Appendix I – Consultation Submissions

Re: Request for comments on EIA Screening and Scoping Document for a Section 261(A) Substitute Consent application and a Section 37L application for further development, in respect of a quarry at Roscat, Adristan, Tullow, Co. Carlow. In relation to Section 261(A) and Section 37L, the provisions of the Planning and Development Act 2000 (as amended) refers.

I refer to your correspondence dated the 26th October 2018 and the Screening and Scoping Document attached.

Following a review of the content of the scoping document, and having regard to the observations received from the Council's internal department, the comments of Carlow County Council are outlined below:

Title: Proposed Site Layout Map

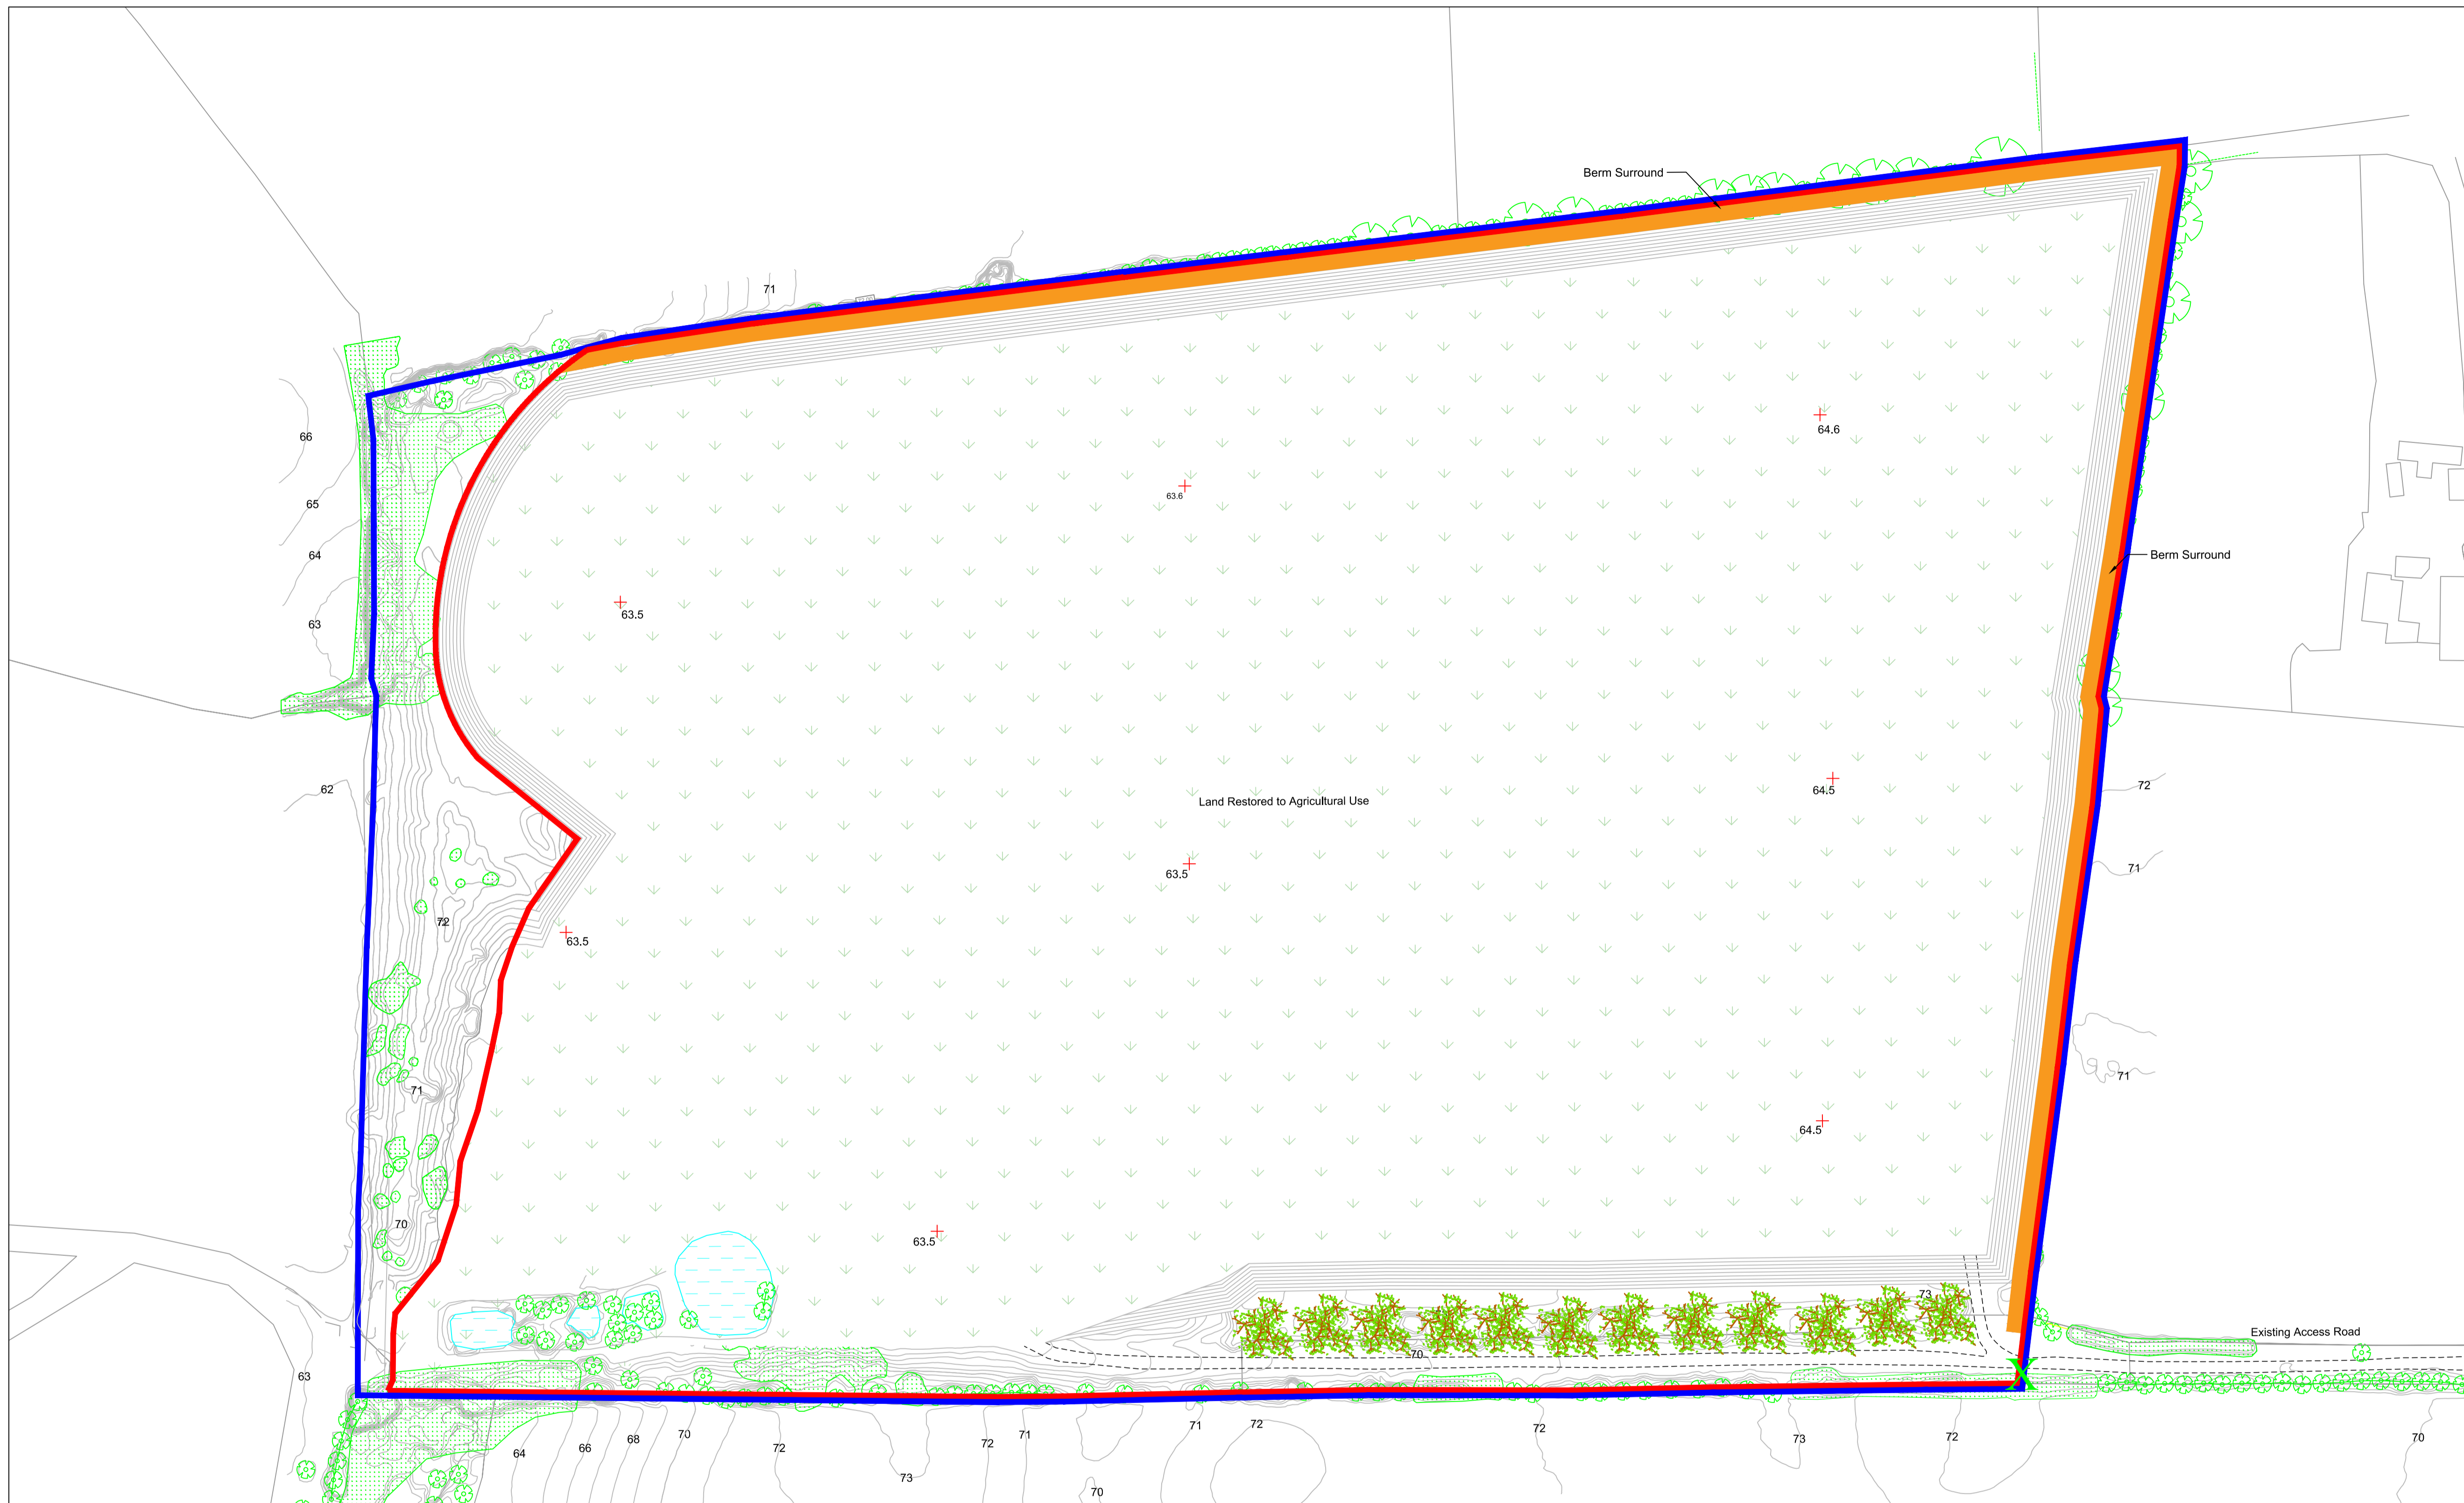
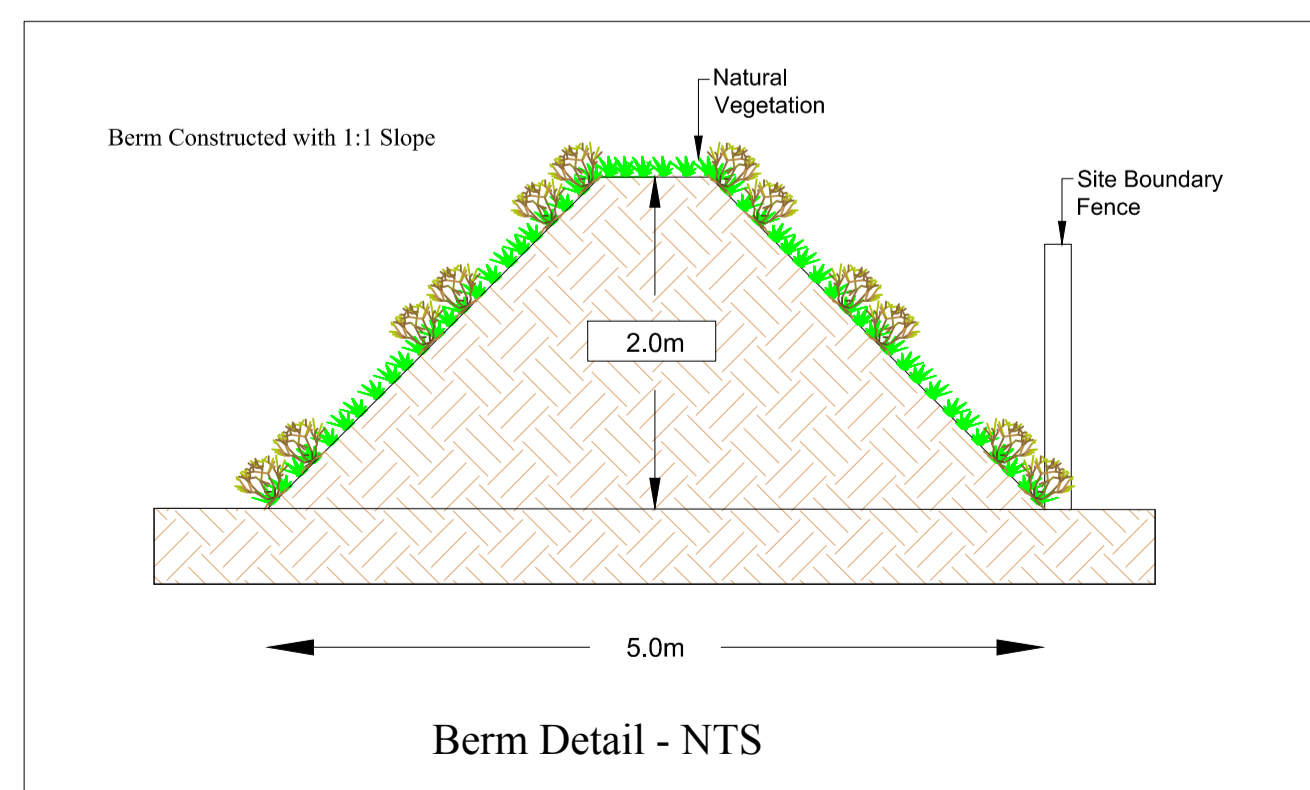
15. Discharges to surface waters from wheel-washes and silt settlement ponds should be subject to S4 Discharge Licences.
16. It is important that the access/haul road, which is 1.1km in length is adequate to cope with the quantity and the type of traffic that this proposal will entail. Of concern to IFI is the fact that the 1.1km haul road between the proposed quarry and the N81 has not been included in the site layout plan.

17. The dirty waters generated from this 1.1km haul road, during times of high rainfall and also from waters used for dust suppression during the Summer months should be addressed.

18. IFI ask if the 1.1km haul road is a paved road or is a hard-core/clay road.
19. We request that all practical steps be taken to minimise dust being generated on this access road.
